January 30, 2024

RE: 2nd Review Responses
Hidden Valley SP (SP23003)

Planning Comments – Kathryn Bird:

**PRELIMINARY SHORT PLAT &
PLANNED RESIDENTIAL DEVELOPMENT
FOR
HIDDEN VALLEY**
SP 23-003

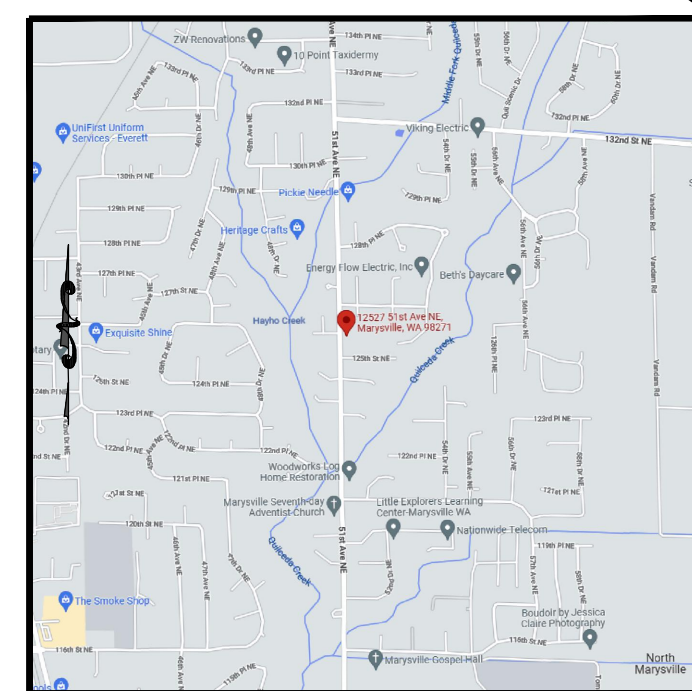
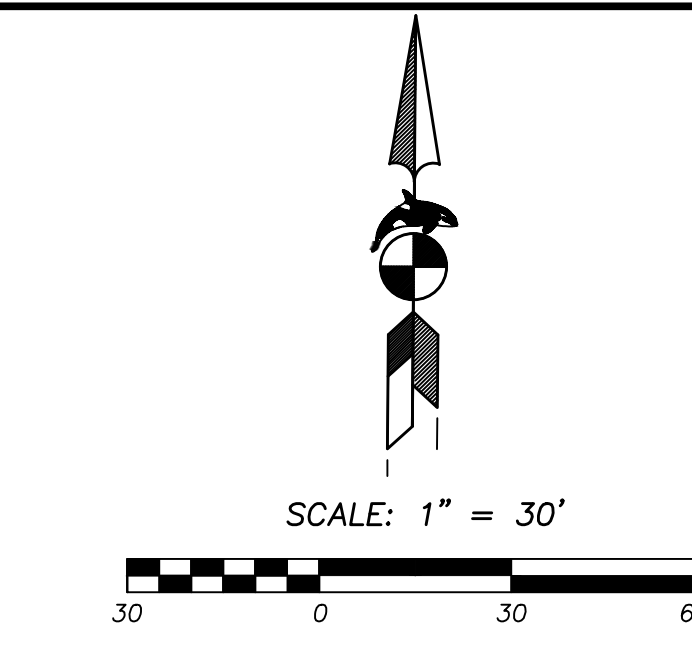
1. Amend the street configuration per memo from Kacey Simon, attached. *Alignment adjusted accordingly after careful coordination with Ken McIntyre.*
2. On Sheet 1 of the Civil Plans, Sheet L1, and the Preliminary Site Plan, adjust the building setback lines on Lots 1 and 3 to not encroach into the drainage easement. *Revised.*

5. Your response letter states that RDIs are no longer proposed. However, the preliminary site plan still shows a calculation for 1 bonus unit. *My apologies, after back and forth with the client and density review RDIs are in fact proposed.*

ROAD & GRADING

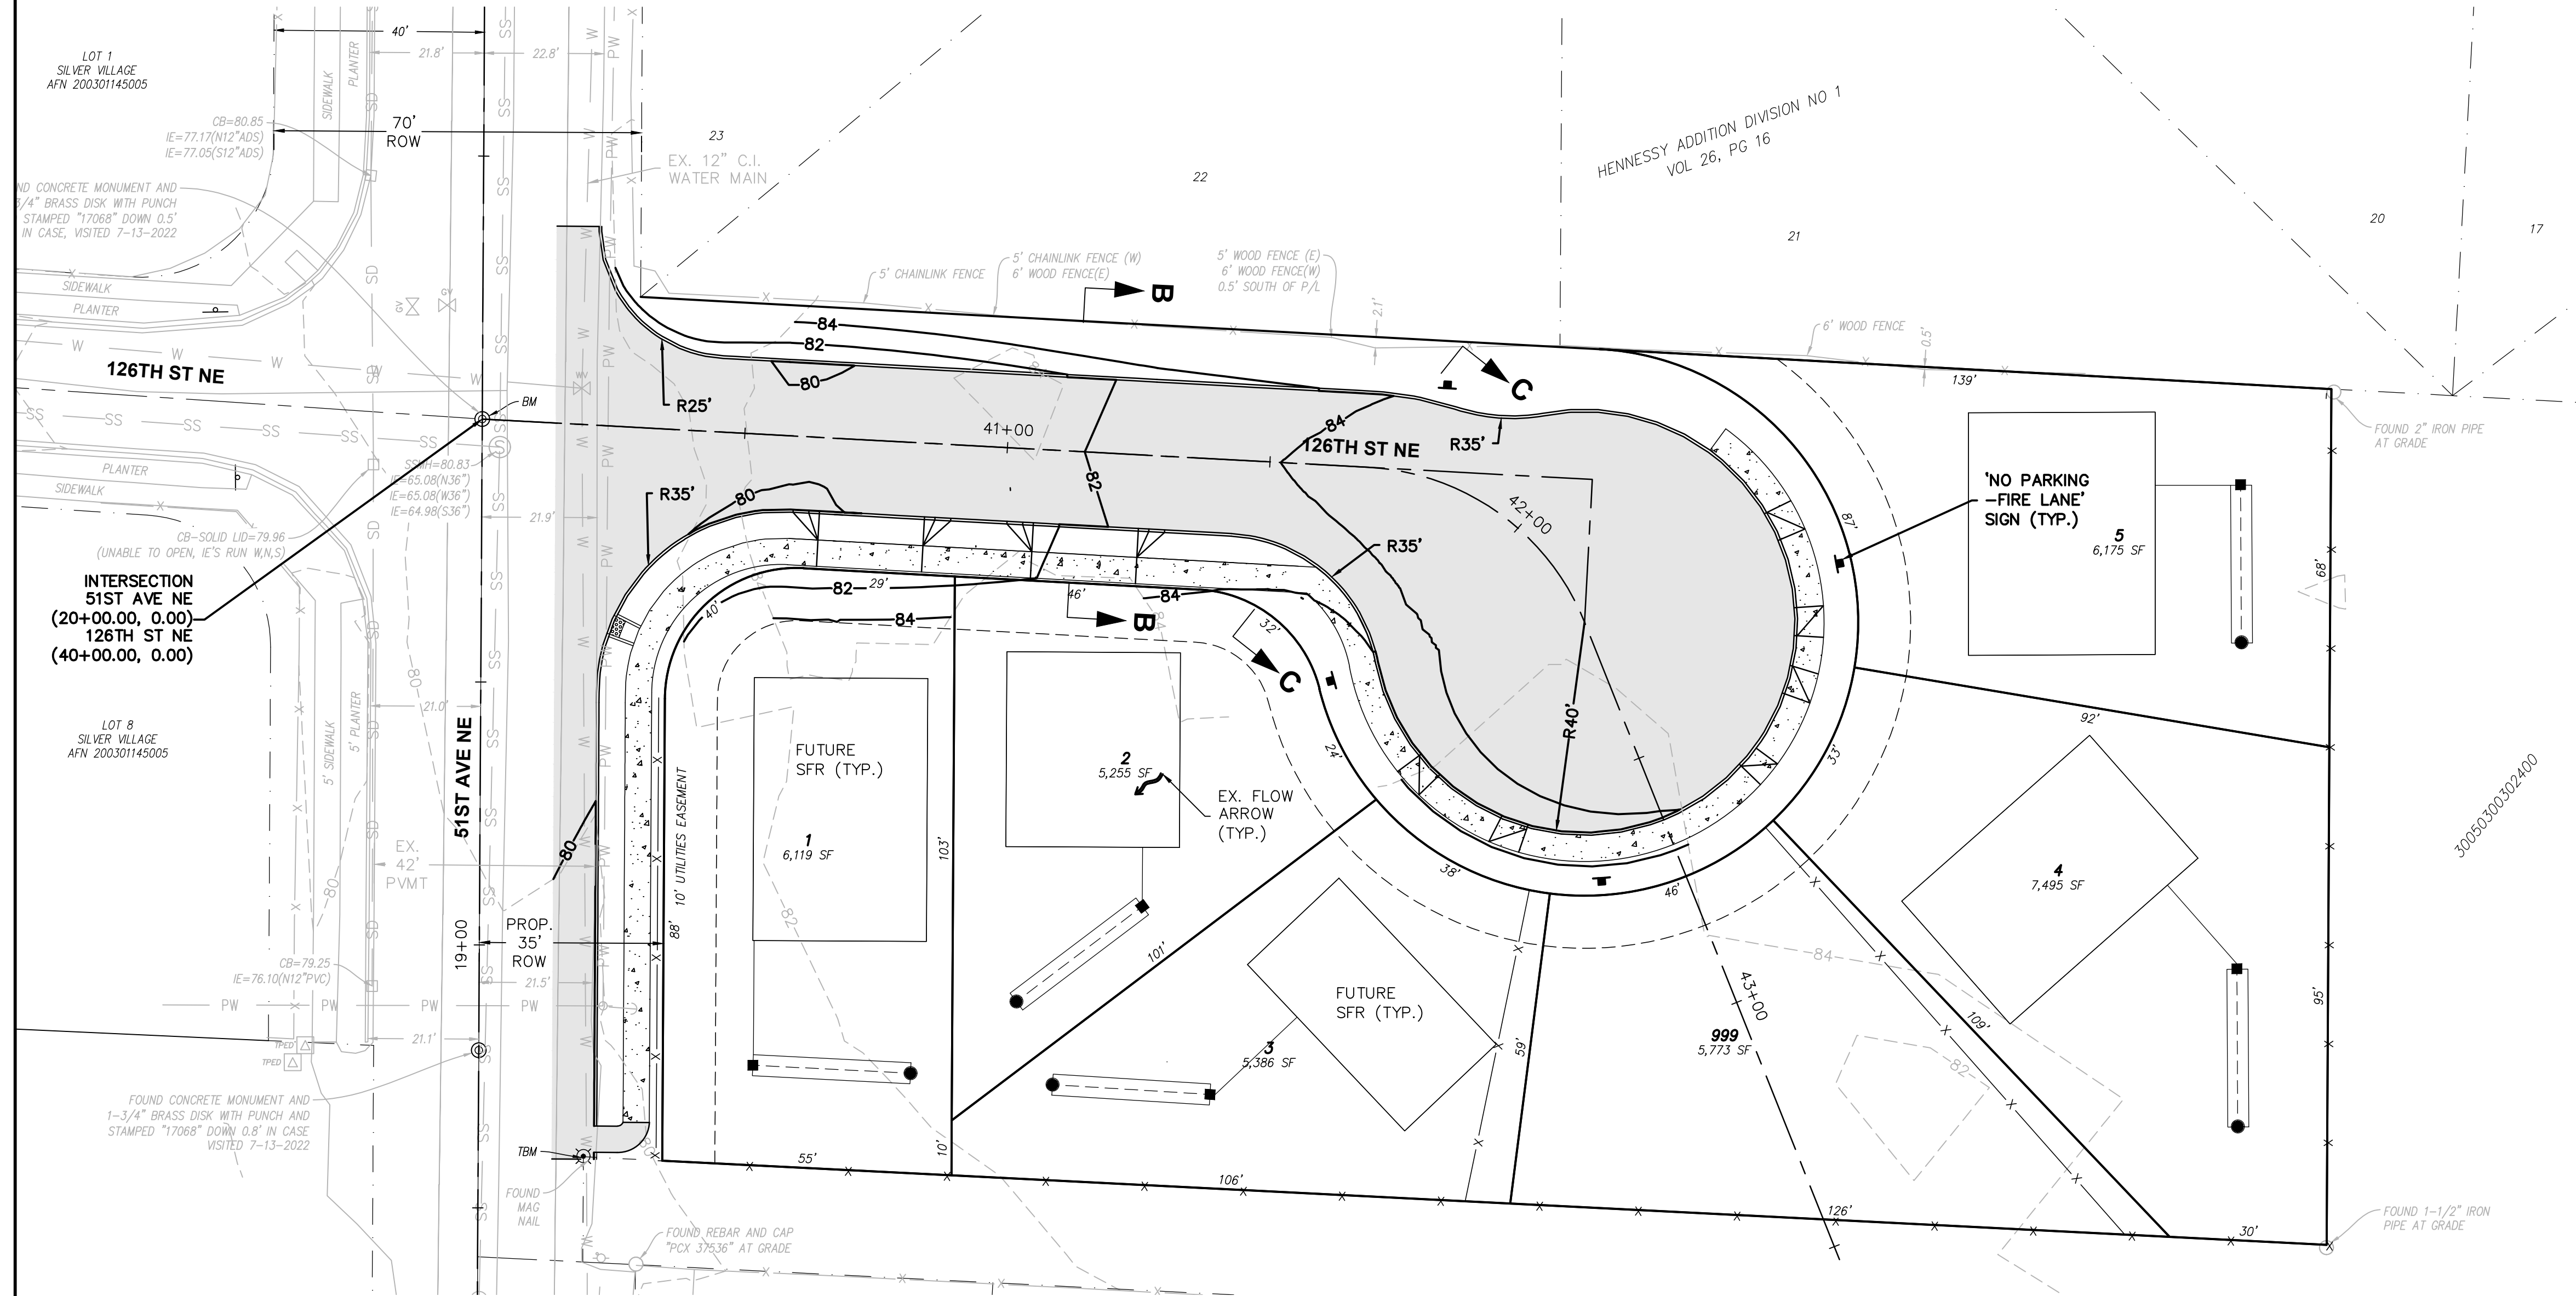
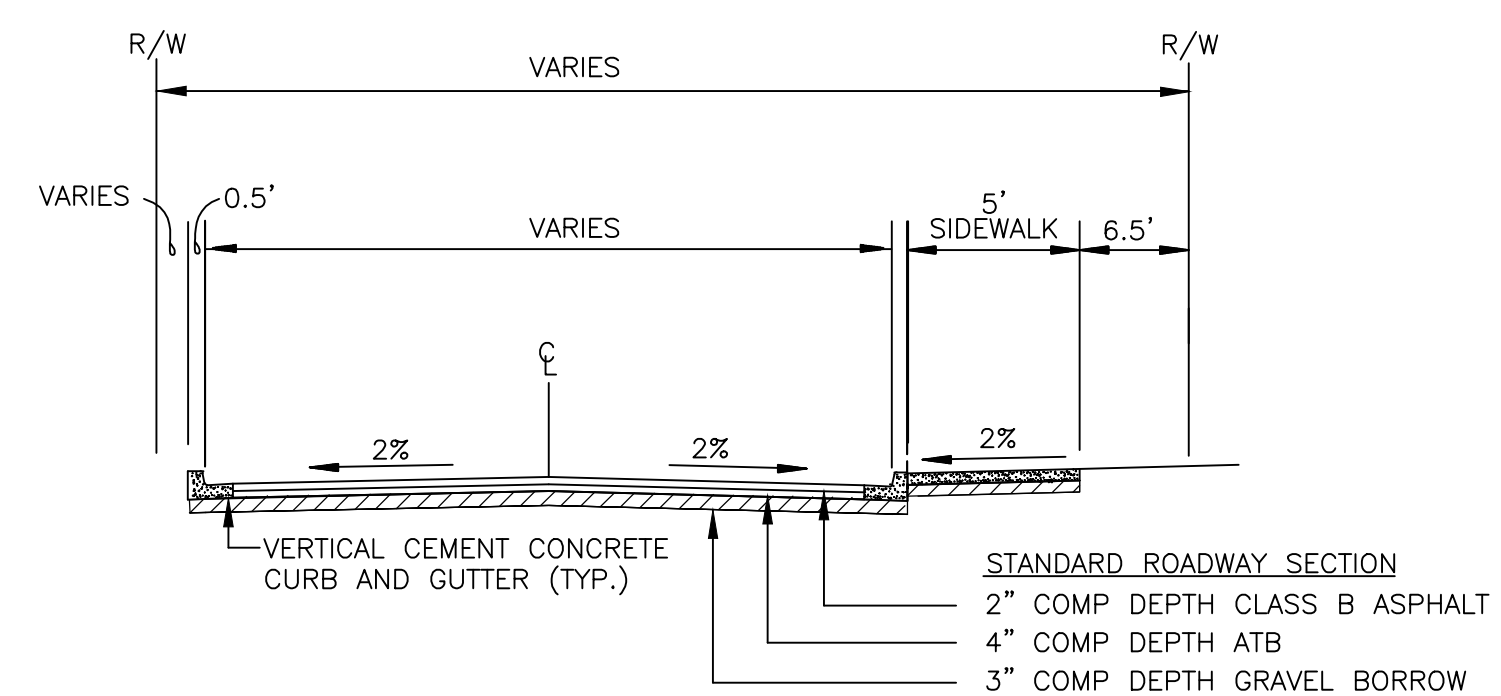
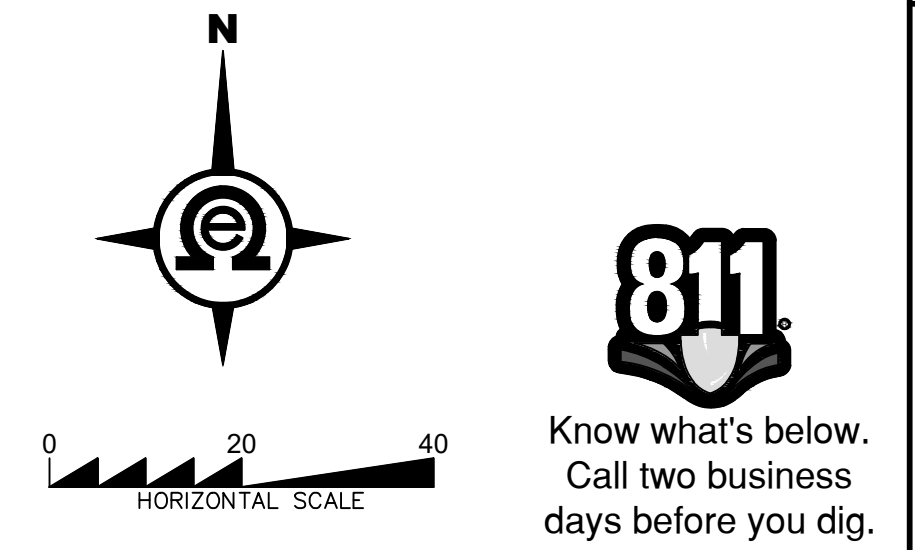
1. *Internal discussions have been had by Land Resolutions with the transportation department to determine that the road can end in a cul-de-sac and continuation to the east is not required.*
2. *A revised variance request has been submitted as part of this resubmittal package addressing the sidewalk on the north side of the new road and the substandard intersection radius at the northeast quadrant.*

**SEWER &
WATER
PLAN**

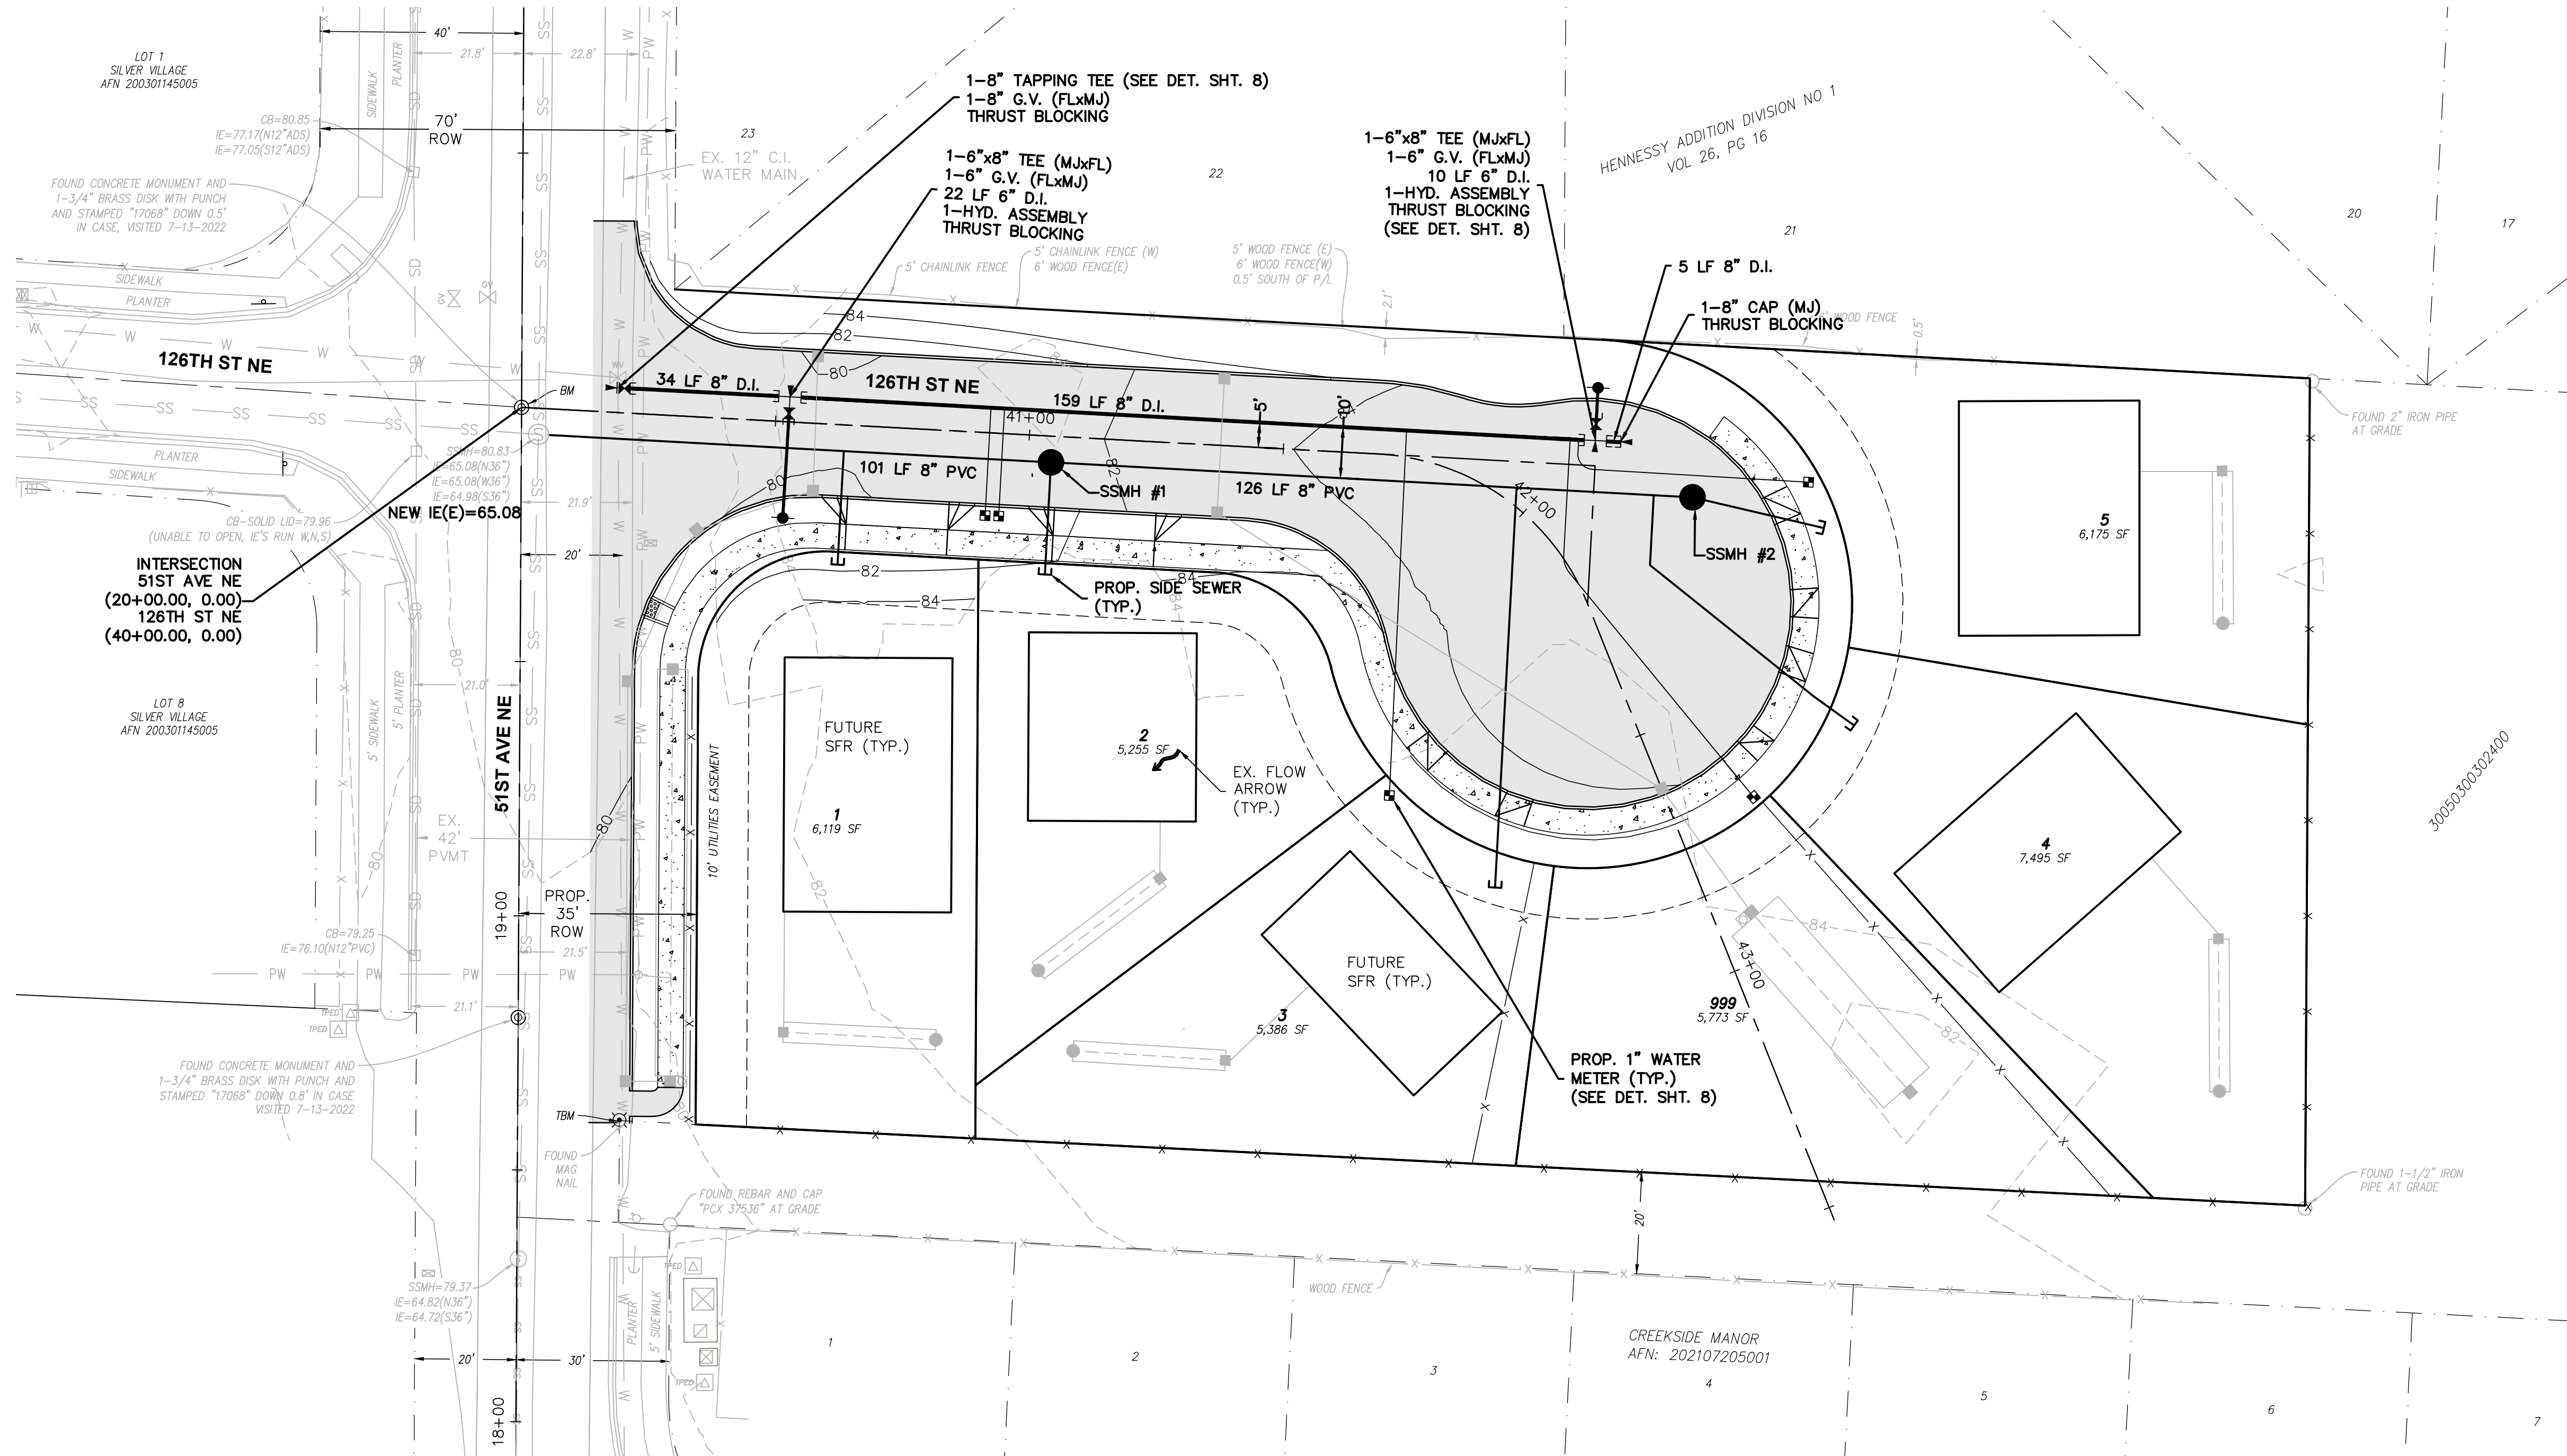
The blow off has been removed and the hydrant moved in its place. Services are shown to be tapped before the hydrant.
